From: Richard Martin
Sent: 19 October 2017 14:43
To: Zac Denton
Cc: Juan Baeza
Subject: FW: R/1/17/T
Attachments: BROOKENBEE CLOSE.R.1.17.T.pdf; COWDRAY DRIVE.R.1.17.T.pdf; HUTCHISON.SUMMERLEY.FOXES.R.1.17.T.pdf; WATERSMEAD DRIVE.R.1.17.T.pdf

To: Richard Martin
Cc: Joe Russell-Wells; Sue Howell
Subject: R/1/17/T

WATERSMEAD DRIVE

BROOKEN BEE

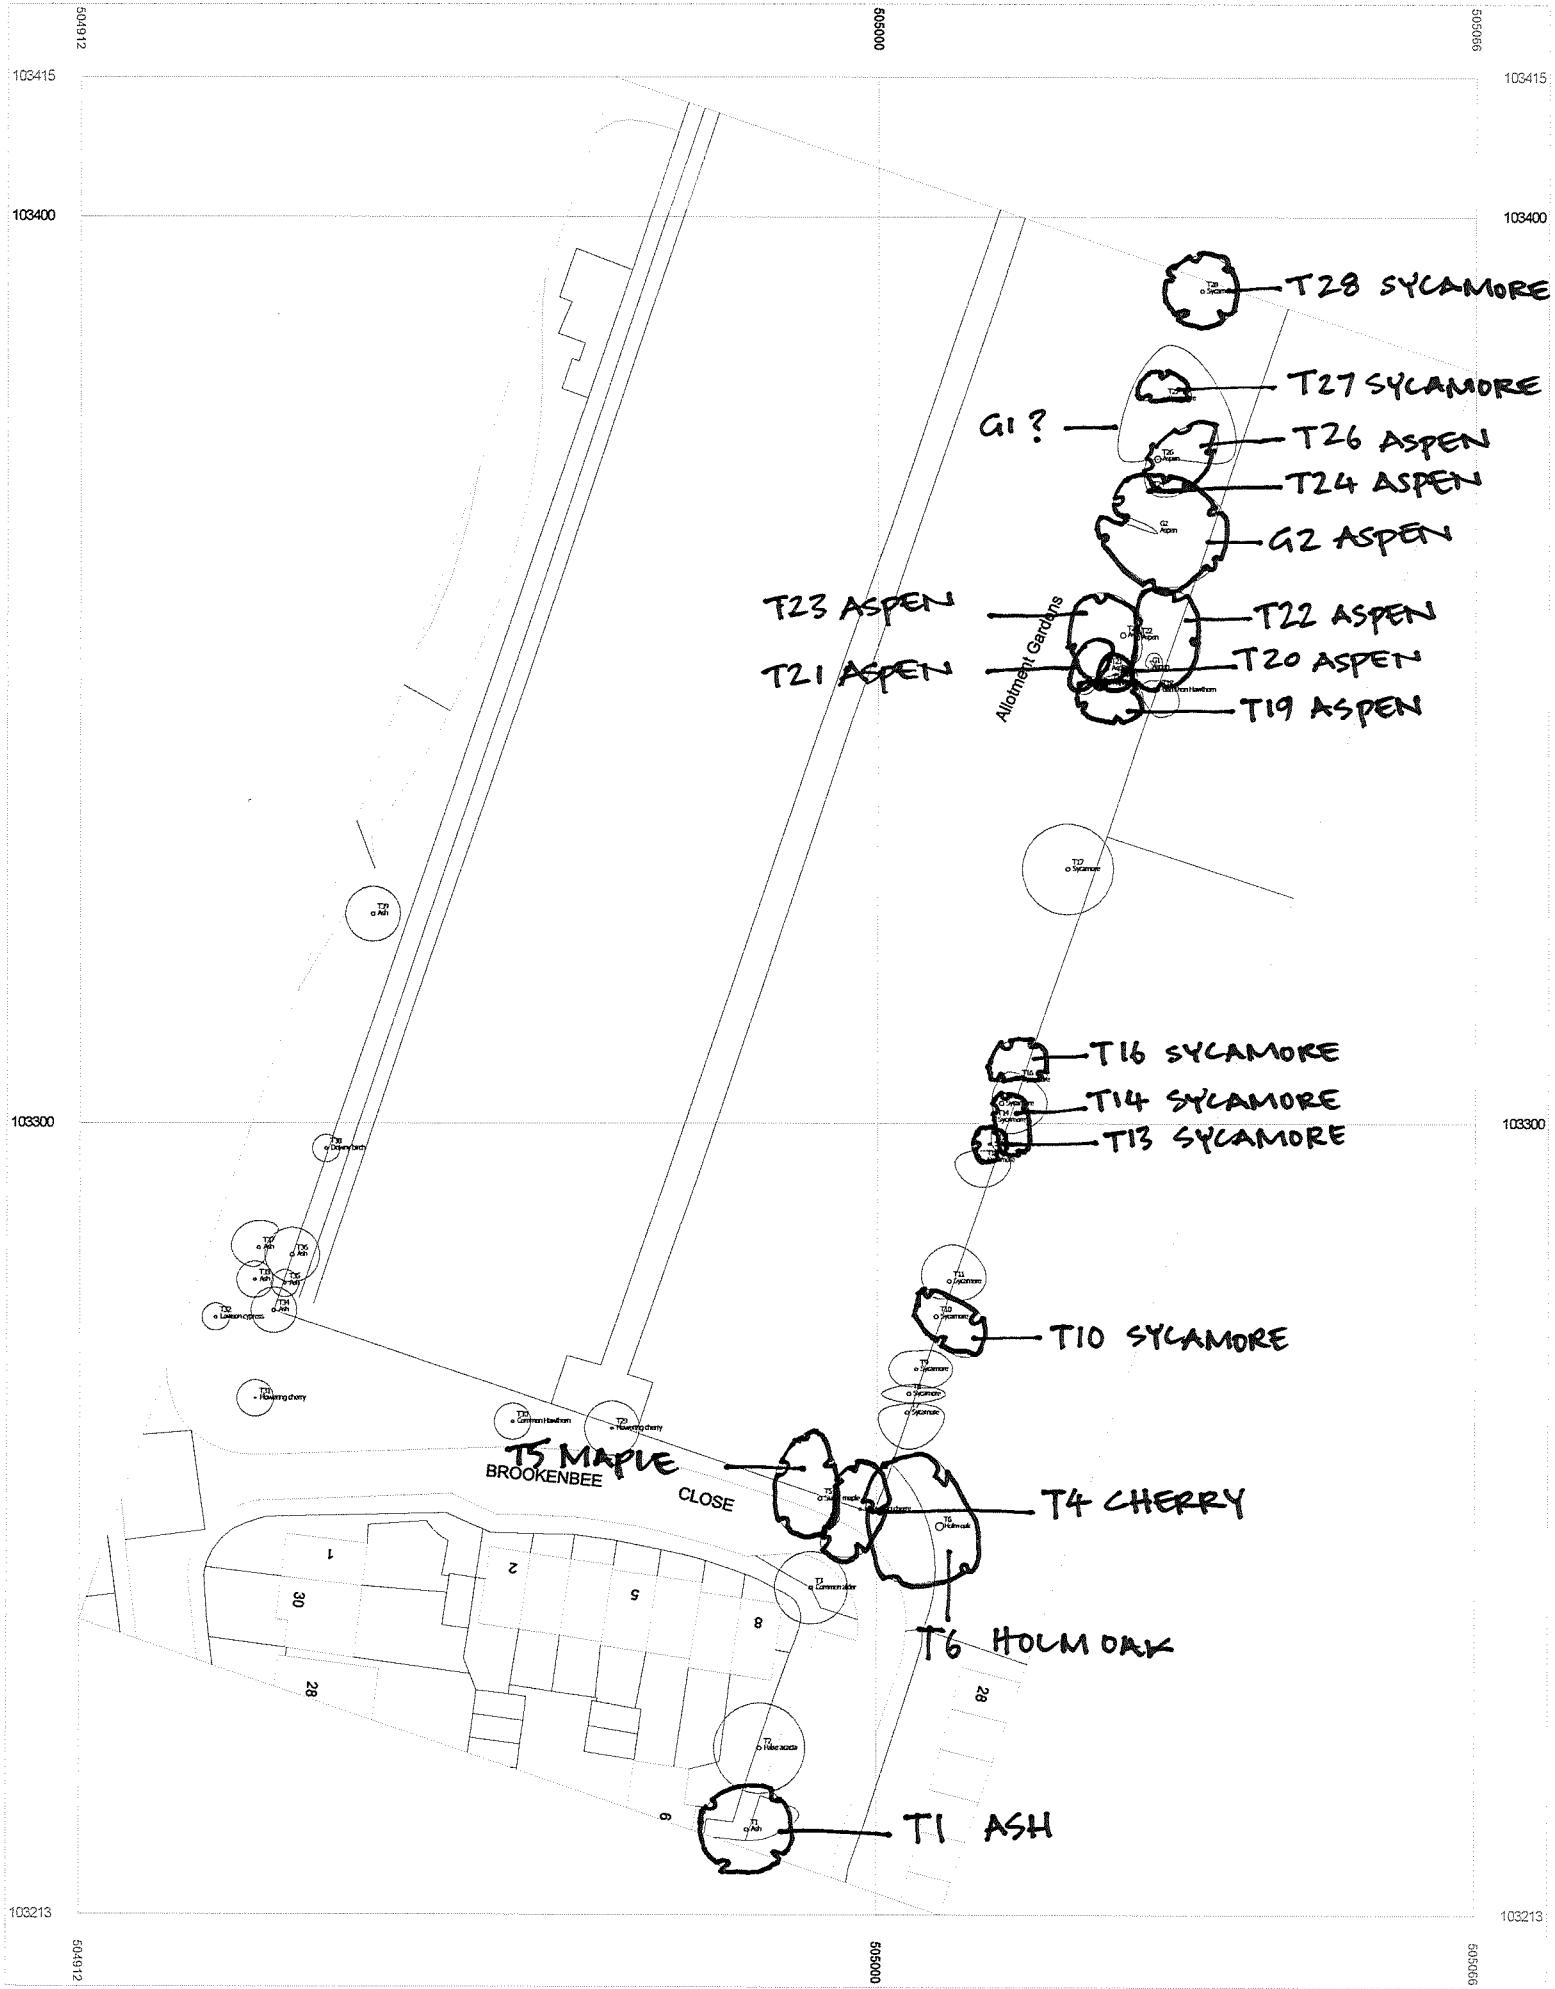
No.	Species	Work Applied For	Works Approved	Works Refused	Advised Works For Re-Submission
T1	Ash	Crown lift to 5m above ground over road	-	5m is excessive and would make large wounds contrary to BS3998 recommendations	Crown lift to a lesser degree of 3m maximum with no cuts over 100mm diameter being formed and seek to reduce the next tier of laterals above this to give the tree a more upswept appearance
T4	Cherry	Crown lift to 5m above ground over road	Crown lift to achieve a 5m ground clearance on the road side of the tree ONLY and make cuts no larger than 100mm diameter.	-	-
T5	Silver Maple	Crown lift to 5m above ground over road	Crown lift to achieve a 5m ground clearance on the road side of the tree ONLY and make cuts no larger than 100mm diameter.	-	-
T6	Holm Oak	Fell	Fell to ground level and then have the stump ground out and a new tree of the same species is to be planted at the same place. This is to be of Heavy Standard Nursery Stock proportions (12-14cm girth & 3m to 4m overall height) supported on a 'short stake' system with appropriate securing ties and pads. It is to be planted within 12 months of the removal.	-	-

T10	Sycamore	Sever or remove ivy	Do not require Council approval for this work	-	-
T13	Sycamore	Sever or remove ivy	Do not require Council approval for this work	-	-
T14	Sycamore	RB included limb at base Cut ivy	Remove branch – included limb at base Do not require Council approval to cut ivy	-	-
T16	Sycamore	Reduce faulted limbs/stems remove included stem at base	-	Reduce faulted limbs/stems remove included stem at base - ?	It is presumed that they mean remove one stem and reduce the remaining stem but no dimensions have been provided for the reduction works – these will be required + confirmation of exactly what they mean.
T19	Aspen	RB Fell southern stem	Remove Branch- fell southern stem	-	-
T20	Aspen	Fell	Agreed – no replacement will be required in this instance	-	-
T21	Aspen	Cut ivy	Do not require Council approval to cut ivy	-	-
T22	Aspen	Reduce faulted limbs/stems reduce included eastern stem to 5m Sever/remove ivy	Do not require Council approval for sever/remove ivy	Reduce faulted limbs/stems reduce included eastern stem to 5m	Reduce by how much – dimension required? Is reduction of eastern stem 5m in from tip or 5m out from trunk?

T23	Aspen	Reduce crowns to boundary Sever/remove ivy	Do not require Council approval for sever/remove ivy	Reduce crowns to boundary	For consistency they will need to specify how much back the tips or out from the trunks?
T24	Aspen	Reduce faulted limbs/stems Remove north east limb back to origin/union Cut ivy	Remove north east limb back to origin/union Do not require Council approval to cut ivy	Reduce faulted limbs/stems	Reduce by how much – dimensions required?
T26	Aspen	CR5 : From trunk 4 to 5m	-	CR5 : From trunk 4 to 5m	Need clarification of what exactly this means – are there 5 branches or is it one limb cut back by 4m to 5m ?
T27	Sycamore	Sever or remove ivy	Do not require Council approval for this work	-	-
T28	Sycamore	Fell	Agreed – no replacement will be required in this instance	-	-

T39	Ash	CR 2 : From trunk reduce west side 2m	-	CR 2 : From trunk reduce west side 2m	Need clarification of what exactly this means – is it 2 branches or is the whole west side to be trimmed by 2m and is this measured out from the trunk or in from the tips?
G2	Aspens	Fell – ground level heavily included stem north of group Cut ivy Reduce faulted limbs/stems Reduce north east limb to main stem	Fell – ground level heavily included stem north of group Do not require Council approval to cut ivy Reduce north east limb to main stem	Reduce faulted limbs/stems	Need dimensions for reduction of faulted limbs?

PARKLAND HUTCHINSON SUMMERLY FOXES, - NORTH

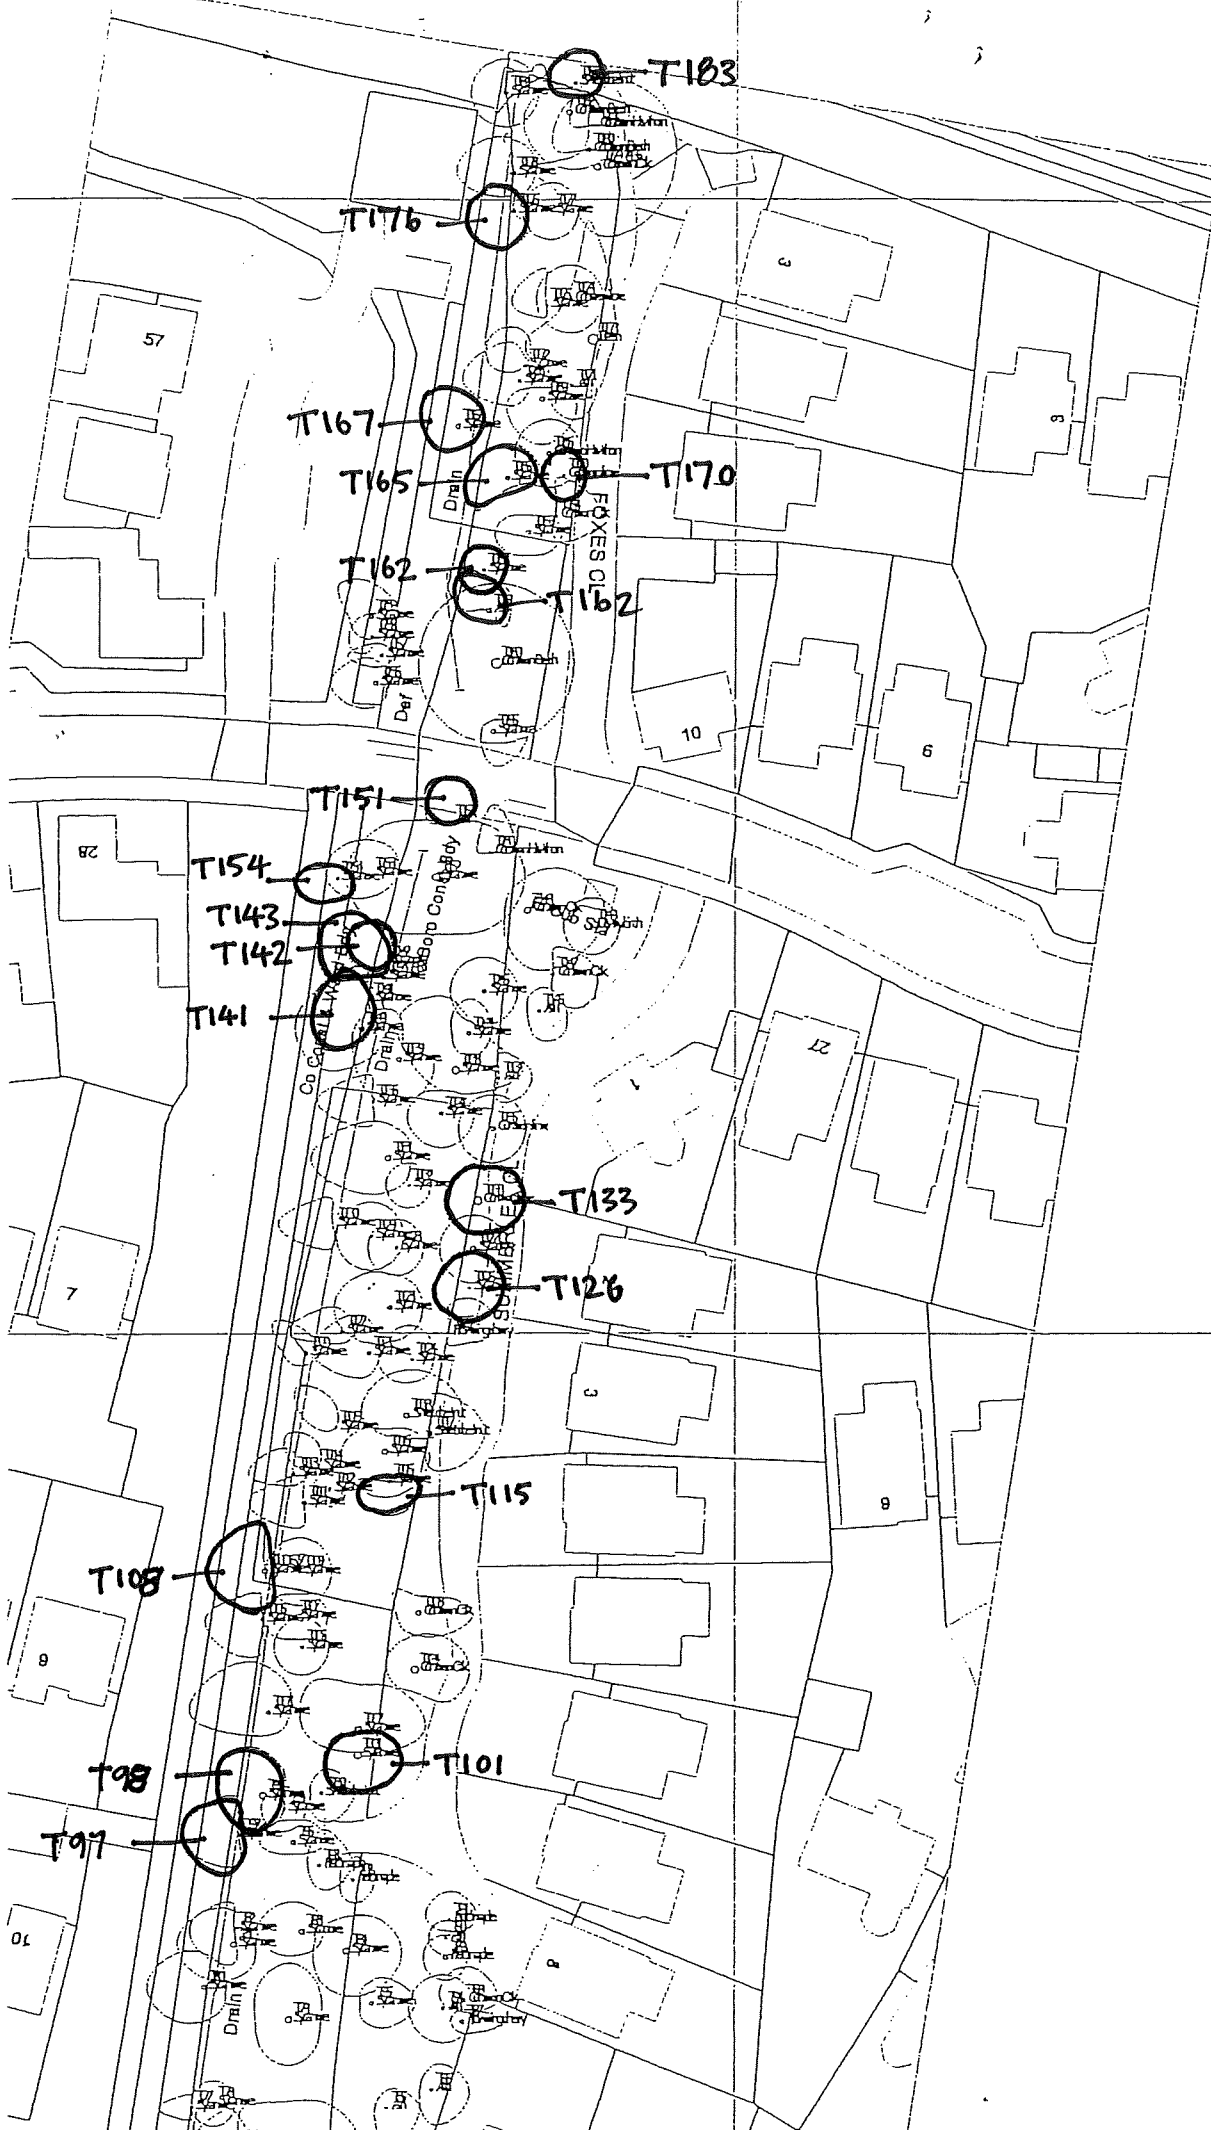
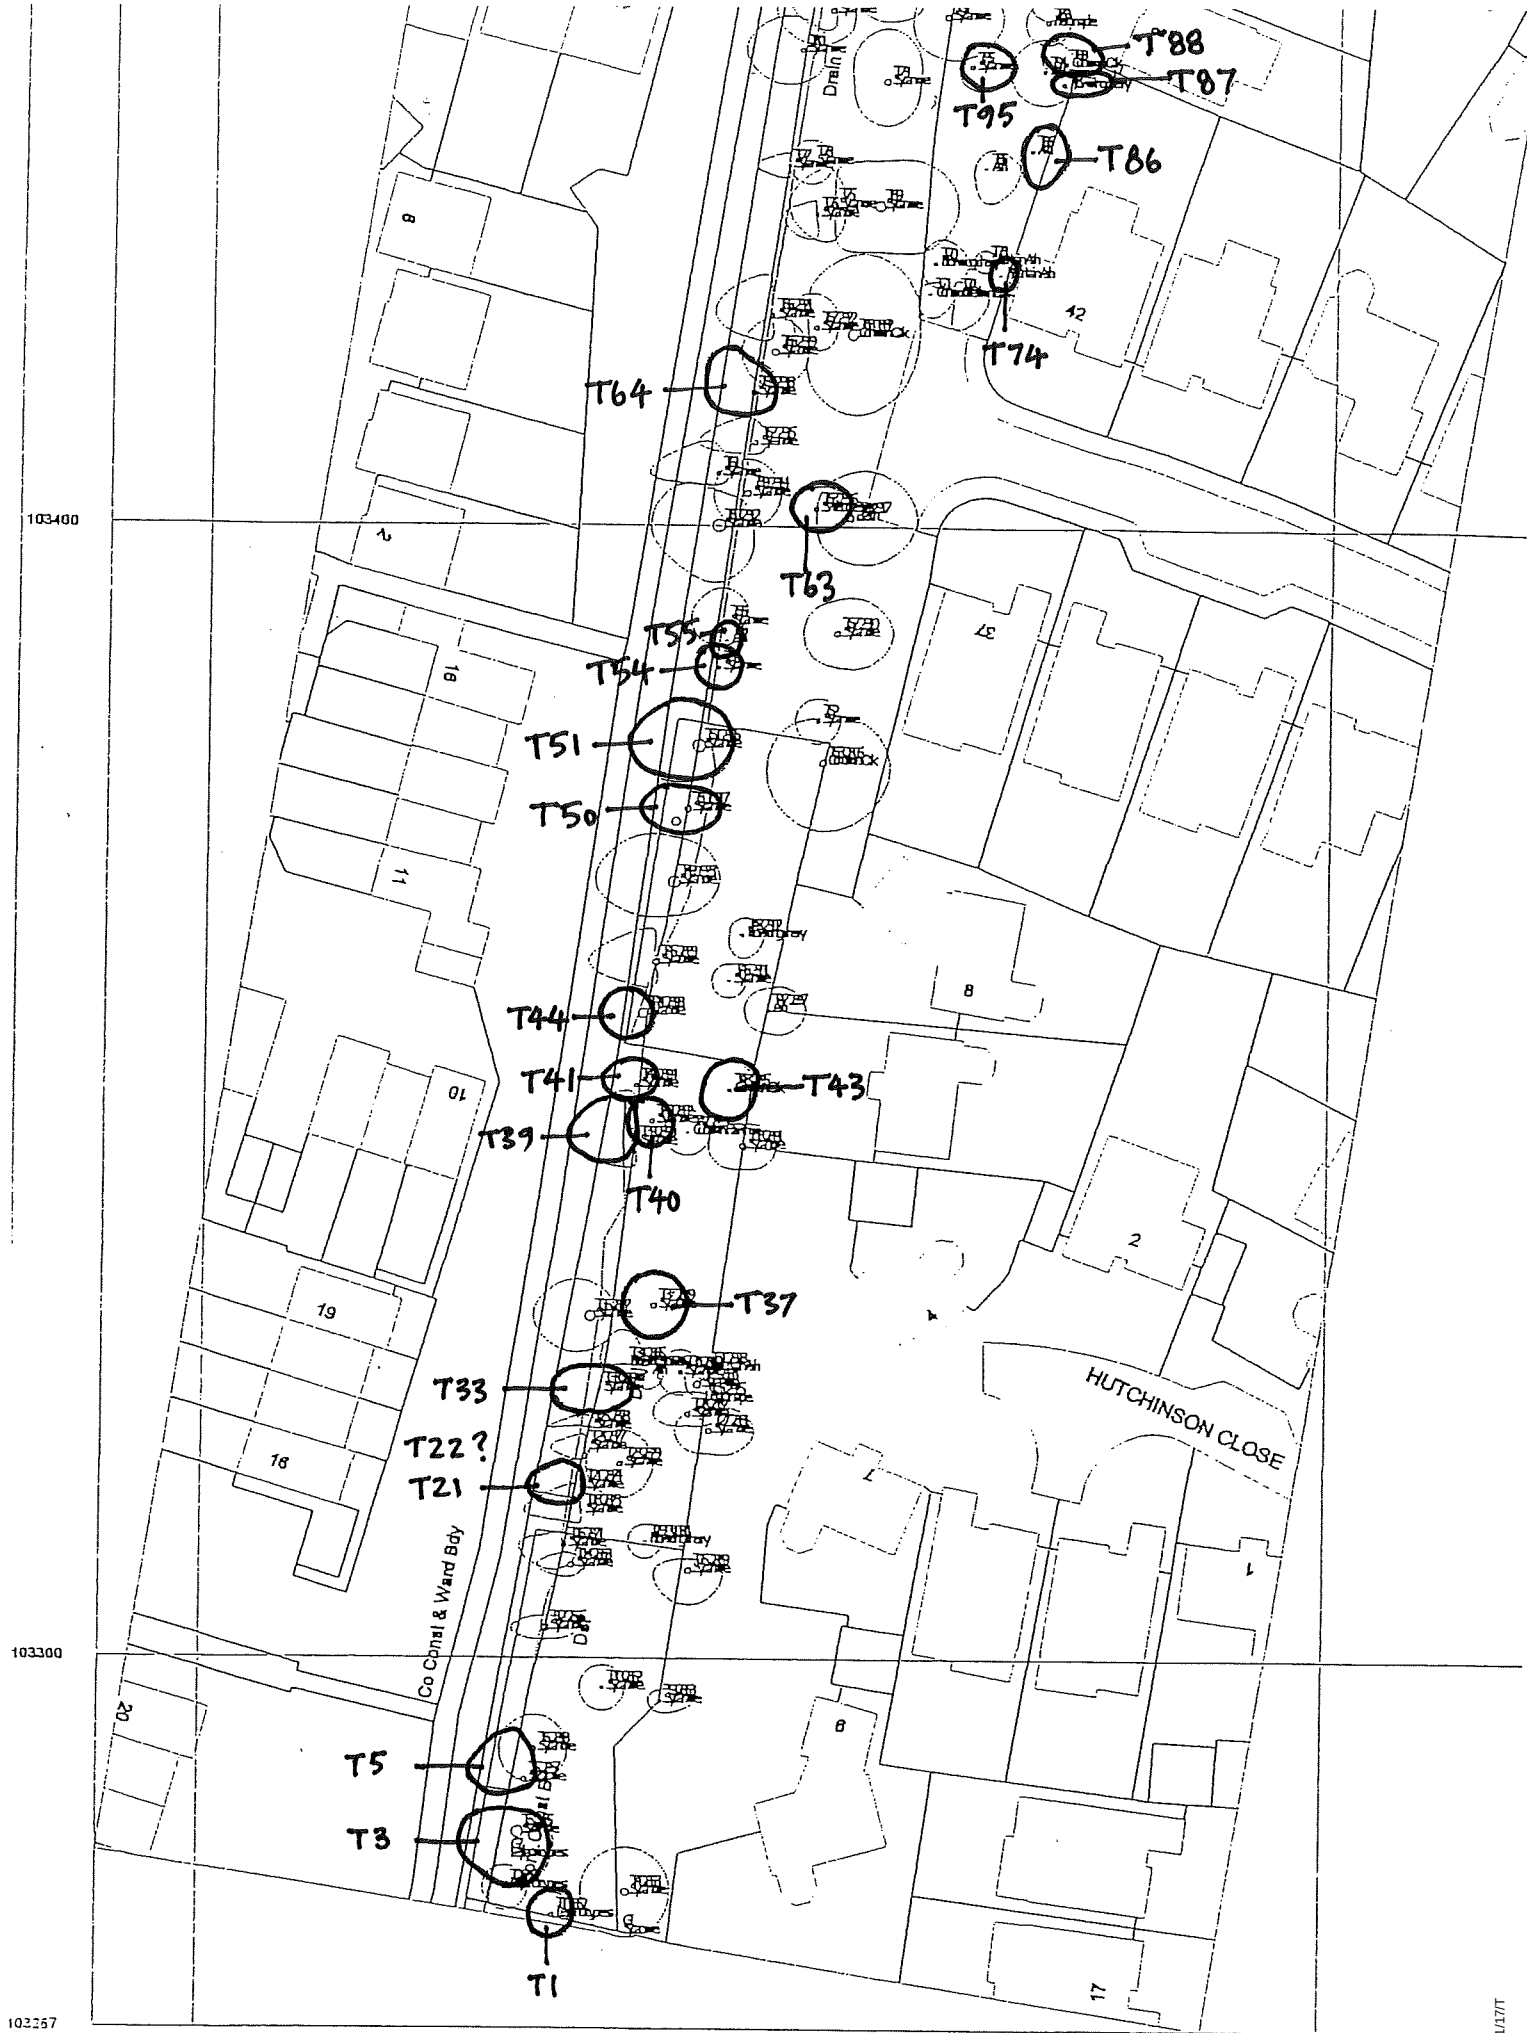
No.	Species	Work Applied For	Works Approved	Works Refused	Advised Works For Re-Submission
T1	Leyland Cypress	Reduce lateral limbs by 1.5m towards adjacent property	Reduce lateral limbs by 1.5m towards adjacent property	-	-
T3	Sycamore	RB remove lowest branch west side originating at 4m	Remove lowest branch west side originating at 4m	-	-
T5	Sycamore	Reduce lateral limbs to west by 2m RH From ground level of southern stem by 4m to suitable growth point	Reduce lateral limbs to west by 2m	Reduce height from ground level of southern stem by 4m to suitable growth point	Do not understand the specification - needs clarification?
T21	Sycamore	CI	Cut ivy – does not need ADC approval	-	-
T22	Sycamore	CI	Cut ivy – does not need ADC approval	-	-
T33	Sycamore	Ivy Sever/remove ivy	Ivy Sever/remove ivy– does not need ADC approval	-	-
T37	Sycamore	Reduce crown(s) reduce height by 2m to 3m	Reduce crown(s) reduce height by 2m to 3m	-	-

T40	Sycamore	Ivy Sever/remove ivy	Ivy Sever/remove ivy– does not need ADC approval	-	-
T41	Sycamore	Ivy Sever/remove ivy	Ivy Sever/remove ivy– does not need ADC approval	-	-
T43	Oak	Ivy Sever/remove ivy	Ivy Sever/remove ivy– does not need ADC approval	-	-
T44	Sycamore	RH From ground level reduce west stem 3m to 4m east by 2m	-	RH From ground level reduce west stem 3m to 4m east by 2m	Do not understand the specification - needs clarification?
T46	Sycamore	Ivy Sever/remove ivy	Ivy Sever/remove ivy– does not need ADC approval	-	-
T49	Sycamore	Ivy Sever/remove ivy DW	Ivy Sever/remove ivy– does not need ADC approval Deadwood - does not need ADC approval	-	-
T50	Sycamore	Ivy Sever/remove ivy	Ivy Sever/remove ivy– does not need ADC approval	-	-
T51	Sycamore	End weight reduction reduce western stem by 2m	End weight reduction reduce western stem by 2m	-	-
T54	Sycamore	RB with squirrel damage	Remove branch with squirrel damage	-	-

T158	Sycamore	Ivy Sever/remove ivy	Ivy Sever/remove ivy– does not need ADC approval	-	-
T159	Sycamore	Ivy Sever/remove ivy	Ivy Sever/remove ivy– does not need ADC approval	-	-
T160	Beech	CC? DW over road	Deadwood - does not need ADC approval	Crossing branches	Will need a better specification from a climbing inspection with photo's to show where they are in the tree and how many and which of each pairing is to be removed to justify actions
T161	Ash	RB remove squirrel damaged nw limb at 4m	RB remove squirrel damaged nw limb at 4m	-	-
T162	Sycamore	Ivy Sever/remove ivy	Ivy Sever/remove ivy– does not need ADC approval	-	-
T165	Sycamore	Fell to ground level	Fell to ground level	-	-
T166	Hawthorn	Ivy Sever/remove ivy	Ivy Sever/remove ivy– does not need ADC approval	-	-
T167	Sycamore	Fell to ground level	Fell to ground level	-	-
T168	Sycamore	Ivy Sever/remove ivy	Ivy Sever/remove ivy– does not need ADC approval	-	-

T171	Ash	Ivy Sever/remove ivy	Ivy Sever/remove ivy- does not need ADC approval	-	-
T172	Sycamore	Ivy Sever/remove ivy	Ivy Sever/remove ivy- does not need ADC approval	-	-
T173	Beech	Ivy Sever/remove ivy	Ivy Sever/remove ivy- does not need ADC approval	-	-
T175	Sycamore	Ivy Sever/remove ivy	Ivy Sever/remove ivy- does not need ADC approval	-	-
T176	Sycamore	Fell to ground level the dead stems	Fell to ground level the dead stems	-	-
T177	Sycamore	Ivy Sever/remove ivy	Ivy Sever/remove ivy- does not need ADC approval	-	-
T178	Sycamore	Ivy Sever/remove ivy	Ivy Sever/remove ivy- does not need ADC approval	-	-
T179	Oak	DW over road	Deadwood - does not need ADC approval	-	-
T182	Beech	DW	Deadwood - does not need ADC approval	-	-
T183	Sweet Chestnut	CR From trunk reduce to boundary with railway	Crown reduce - From trunk reduce to boundary with railway	-	Advisory – would be better to remove the tree altogether
